Copse Acre
Copse Lane
Walberton
Arundel
BN18 0QH

14 May 2021

Planning Application WA/32/21/PL
Land West of West Walberton Lane

House Type 3BH3

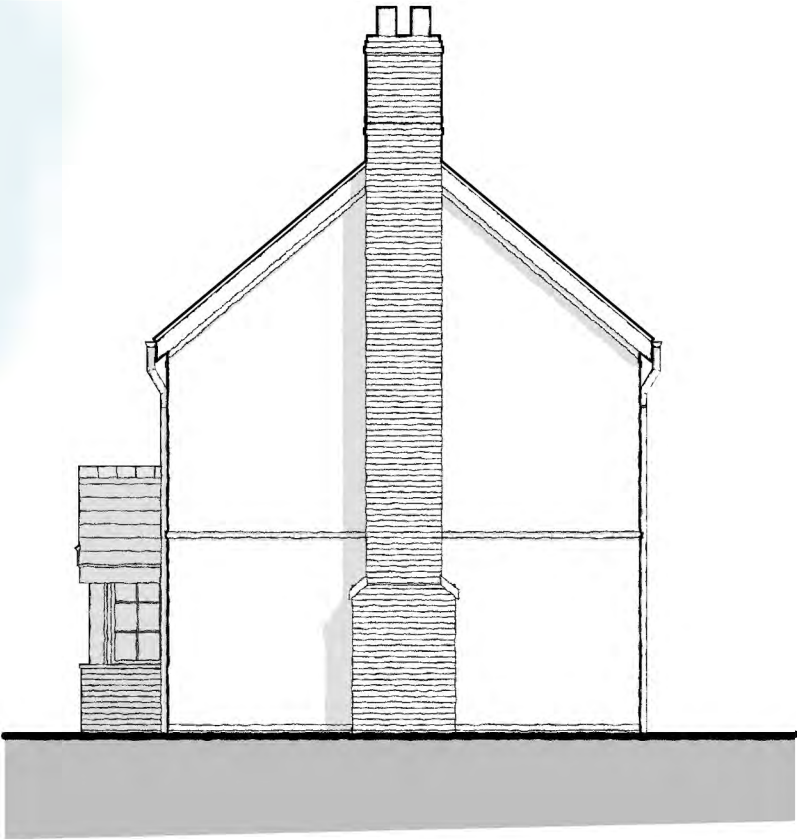
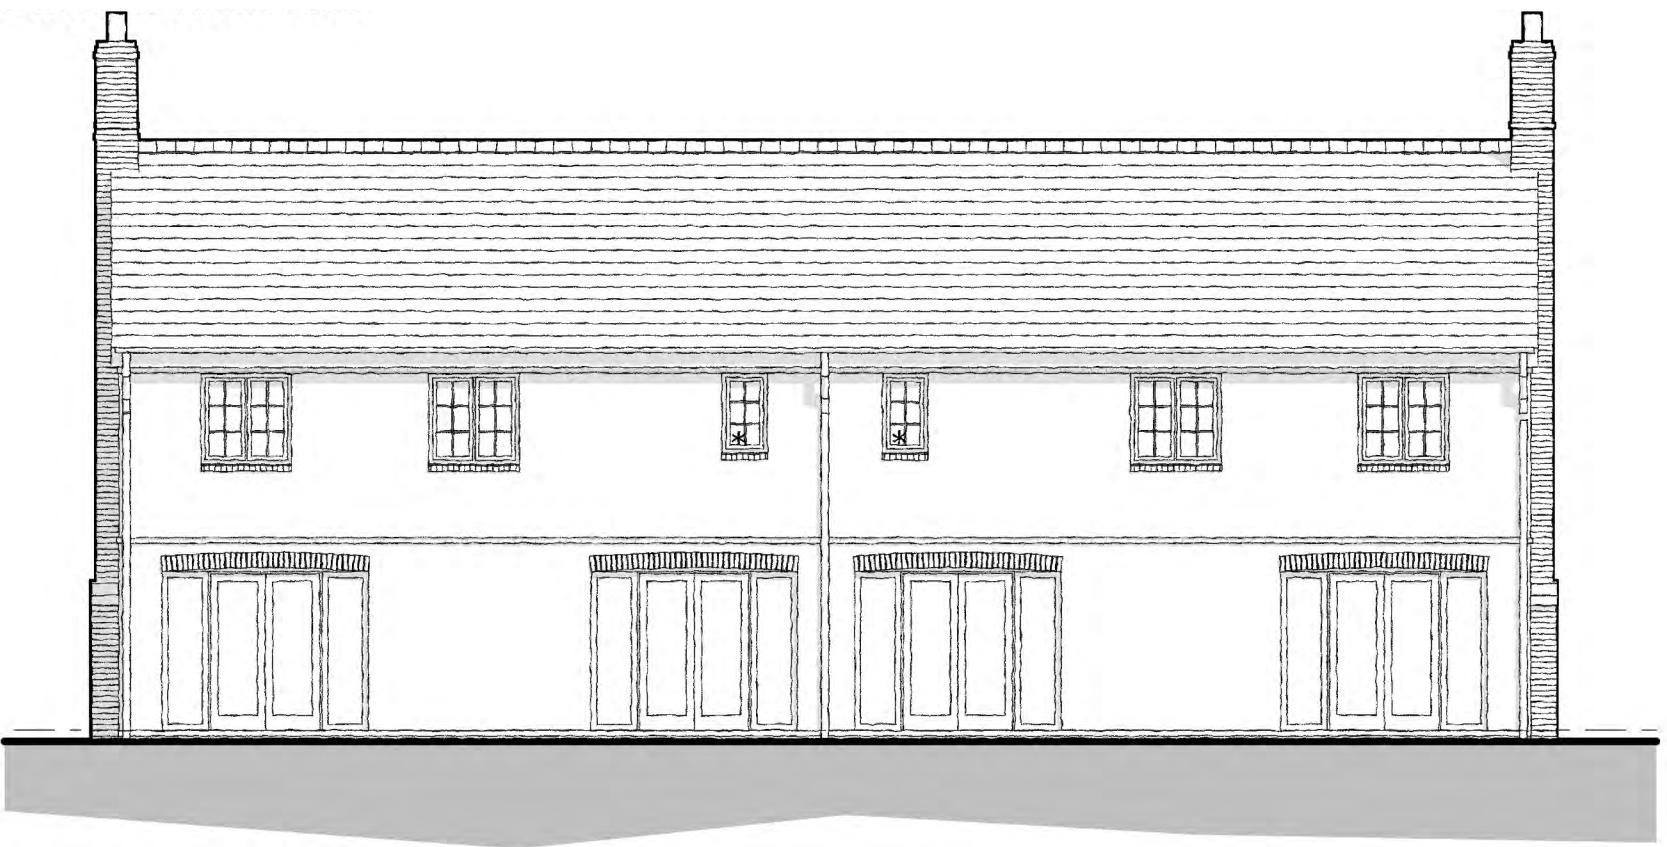
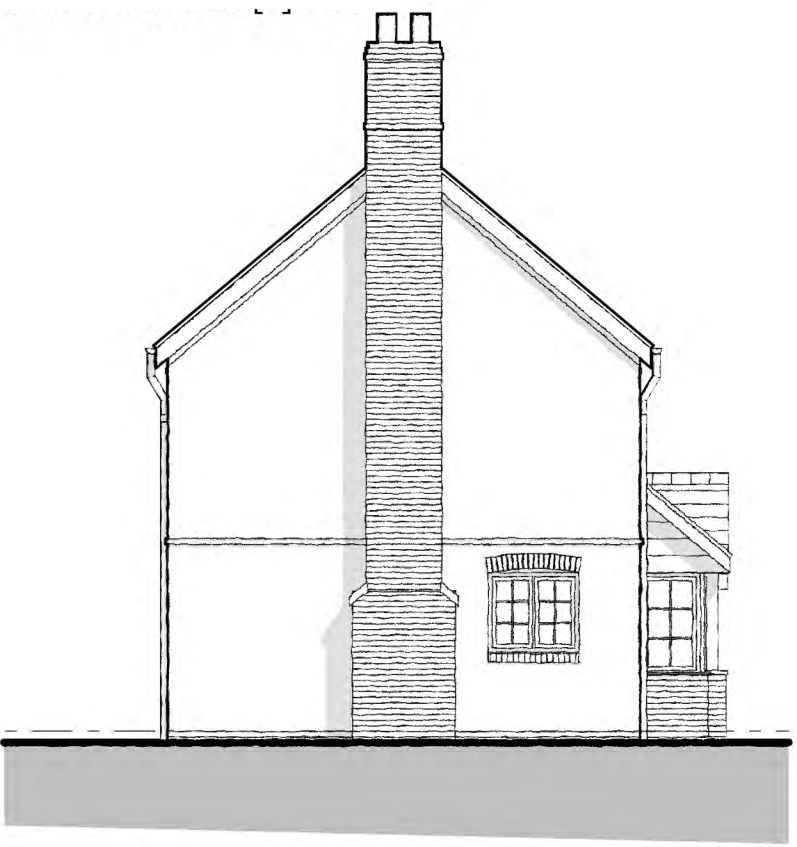
Section 21 of the Application states that the site is not visible from a public road or other public land. This is incorrect. The site is almost wholly visible from Eastergate Lane and is also visible from the Village Green and parts of West Walberton Lane. The “high-rise” nature of the buildings, with two levels and steep-pitched roofs, will dominate the surrounding low-rise housing as well as the Green and will seriously detract from the rural nature of the village.

The design of the site buildings is completely out of character with the surrounding existing buildings. The use of bright-red tiles, red brick and timber facing is garish and clashes with the materials used elsewhere in the neighbourhood.
